Single storey front extension, side extension, conversion of garage to habitable use and conversion of roofspace to habitable use to include a rear dormer and 3 front rooflights.

22 Singleton Crescent Ferring

Thank you for your internet representation made on 10th May 2019 which has been recorded as **'an objection'** with the comments as follows:

AR-138-07

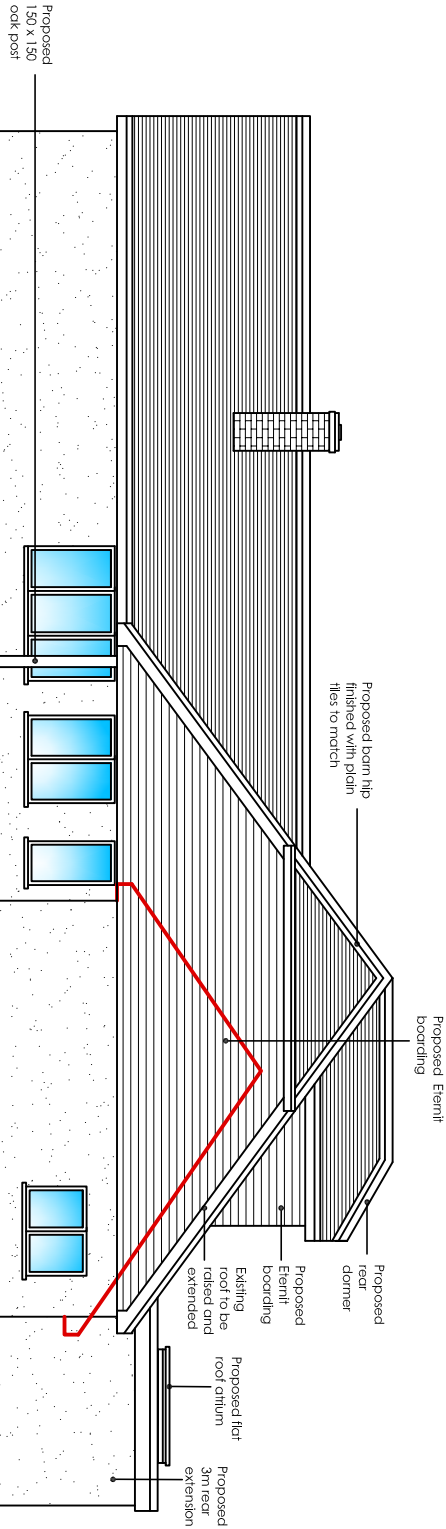
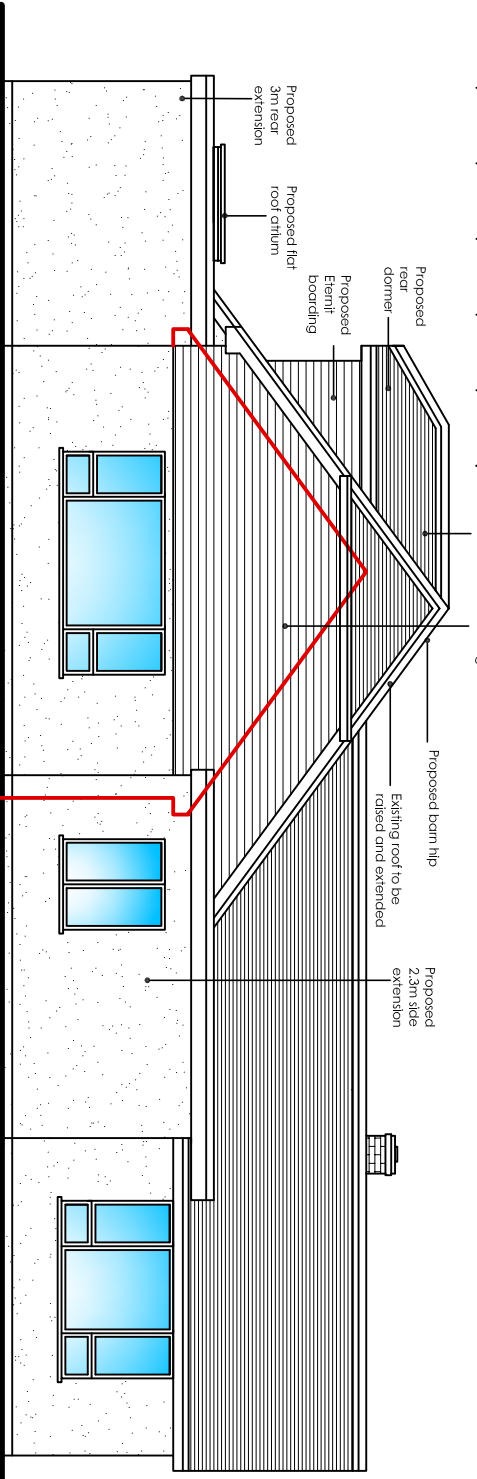
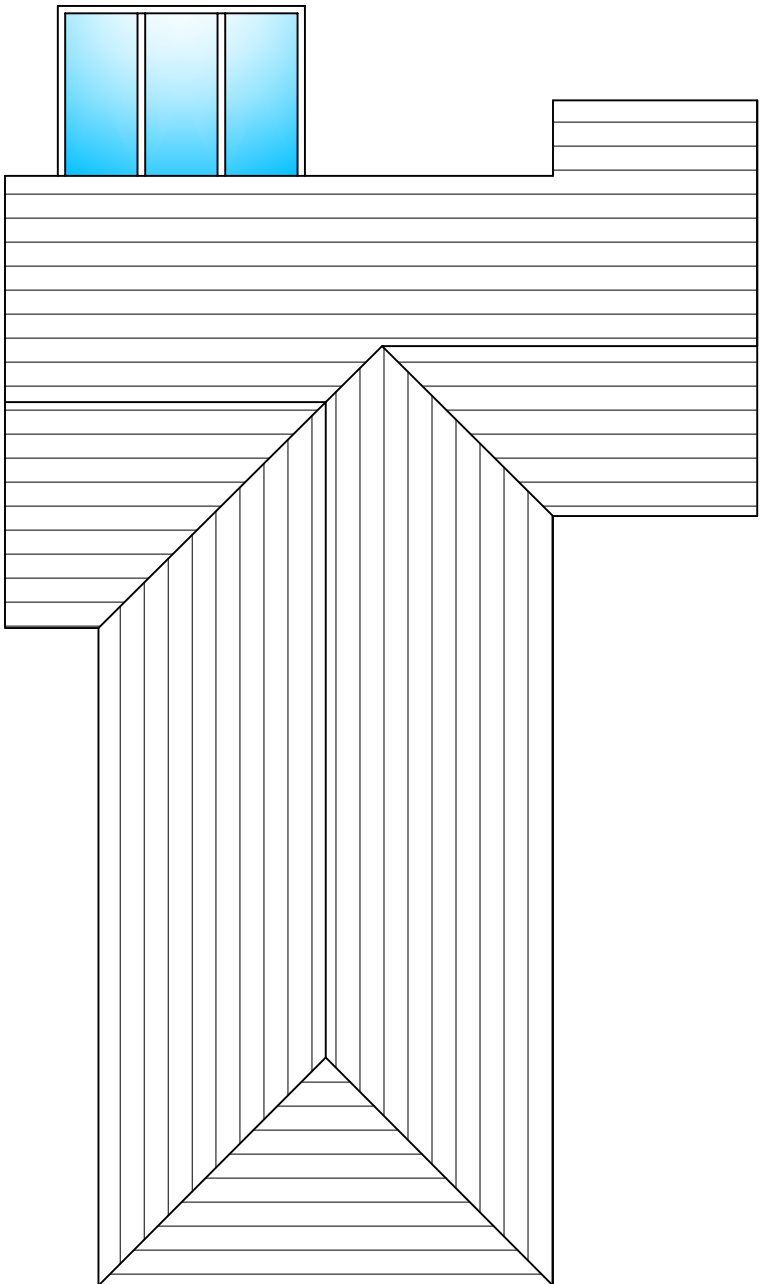
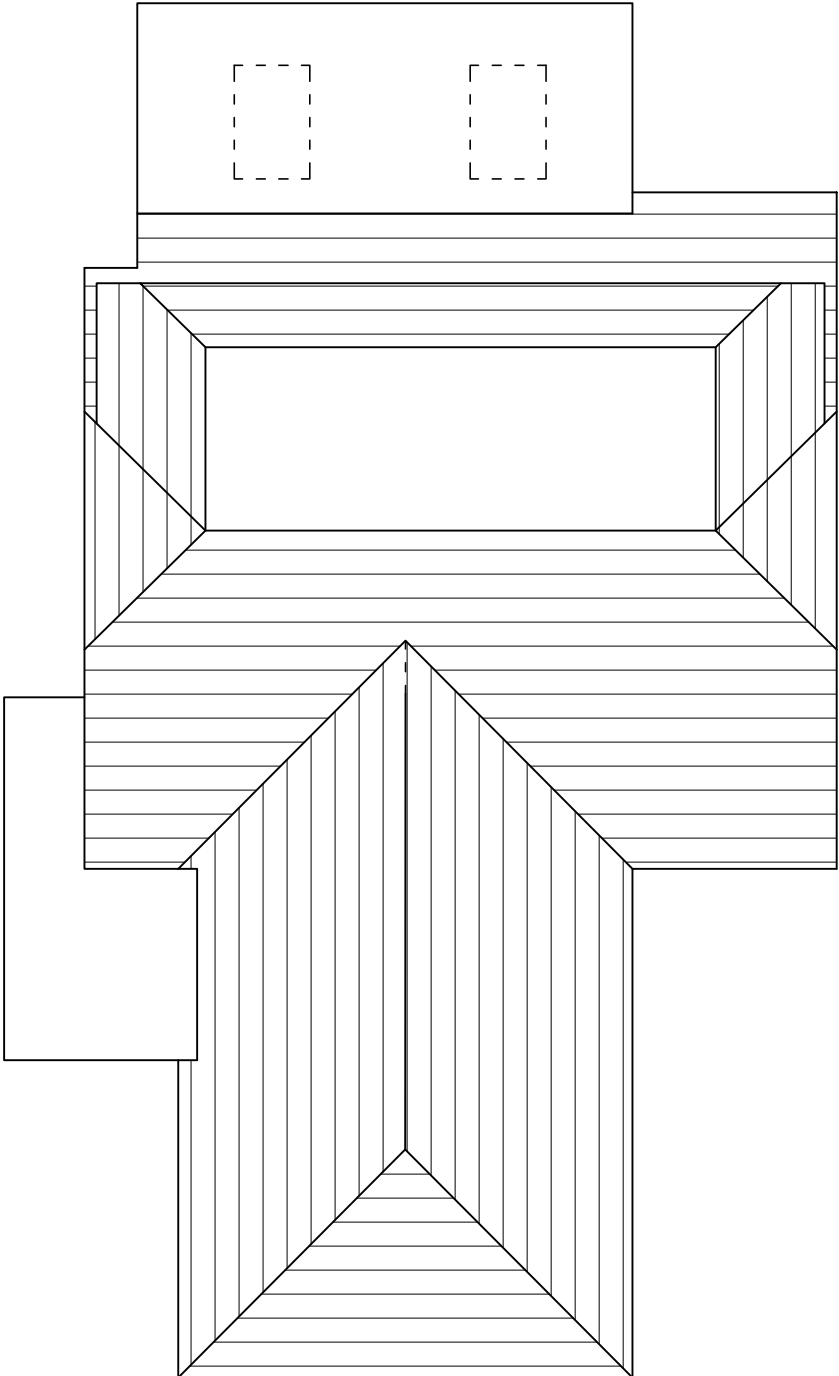
*1. The Architects planning notes on the drawing No AR-138-07 are misleading. Note 1 states that no.27 is opposite- this is not correct, No 45 (my bungalow) is opposite No. 22. No. 27 is tucked away in a corner on a large plot hidden behind some very large trees approx 160 yards away.*

*2.Note 3 referring to the building extension at No.28 was actually built within the existing roof space and does not affect the appearance of the street.*

*3.The proposal to raise the roof by that amount will completely alter the appearance of the street and will have a detrimental impact on its appearance. This is exaggerated because No. 22 is in prominent position on the front of a bend.*
